**Albuquerque Studios Master Plan
Development**

Traffic Impact Study

January 4, 2022

The following two sections in the Executive Summary list agency comments received on the draft TIS submission along with responses provided for this final TIS.

Figure 17
Buildout Year Lane Configurations and Traffic Control
37

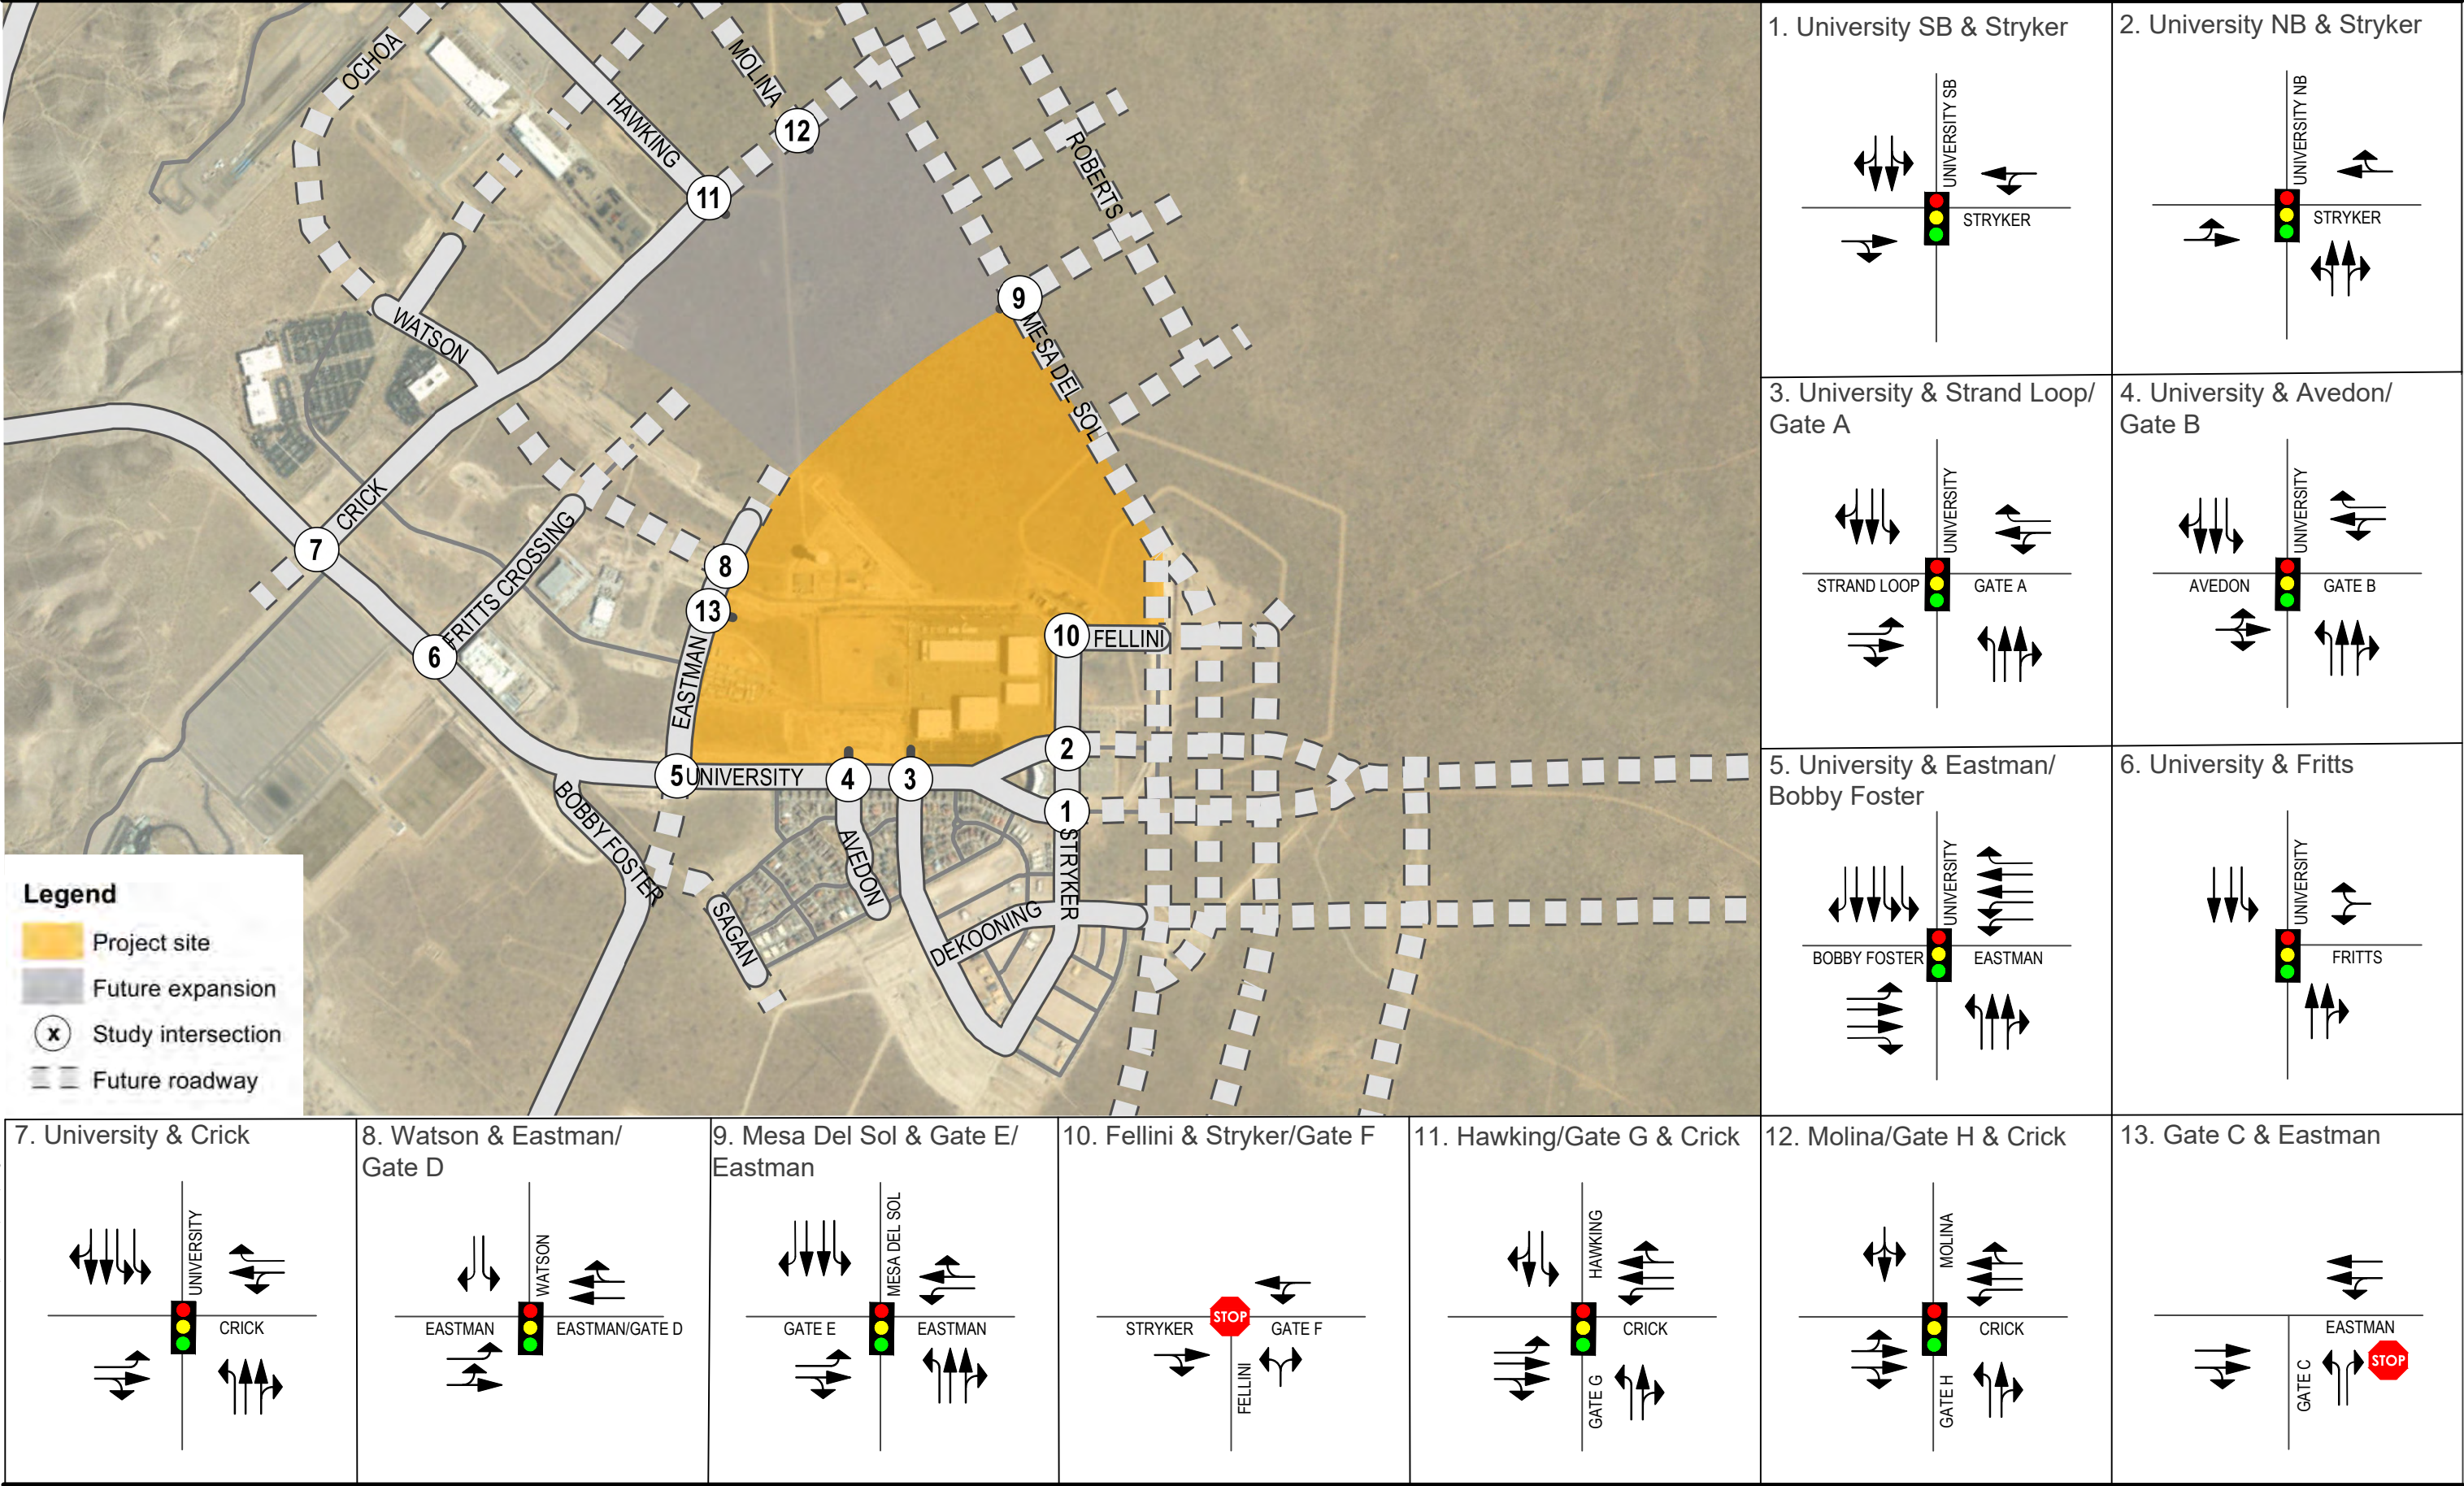
Intersection 1: Stryker west side of University

- Stryker EB right – (Montage Traffic) – Provide drawing of the intersection showing constraints
- University SB left - (Netflix traffic) – Left-turn stripe and sign the southbound left lane as a combination through/left-turn lane
- Stryker WB left – (Montage traffic)- Provide drawing showing constraints

Intersection 2: Stryker east side of University

- University NB left - (Montage traffic)
- Stryker WB right - (Netflix traffic) - Not Feasible per building note above (Intersection 2, 2026 with project)

Intersection 8: Watson/Eastman

- Eastman EB left - (Netflix traffic) – 11' left turn lane within 18' median
- Watson SB right - (Netflix traffic) – 11' right lane (8' parking and 3' landscape)

Intersection 9: Eastman (Gate E) Eastbound / Mesa del Sol Blvd. (NB/SB)

- Mesa del Sol NB right Eastman - (bypass traffic)
- Mesa del Sol SB left - (bypass traffic) – 11' left turn lane within 18' Median
- Eastman WB right - (bypass traffic) – Add 11' right turn lane (8' landscape and decrease sidewalk to 5' width at intersection)
- Eastman WB left - (Netflix traffic + bypass) – 12' left turn lane

Intersection 12 Molina/Crick:

- Crick EB left - (Netflix traffic) – not feasible, center lane not within section
- Molina SB left - (Netflix traffic) – 12' left turn lane
- Crick WB right - (Netflix traffic) – 11' right turn lane (8' of parking and 3' of landscape)
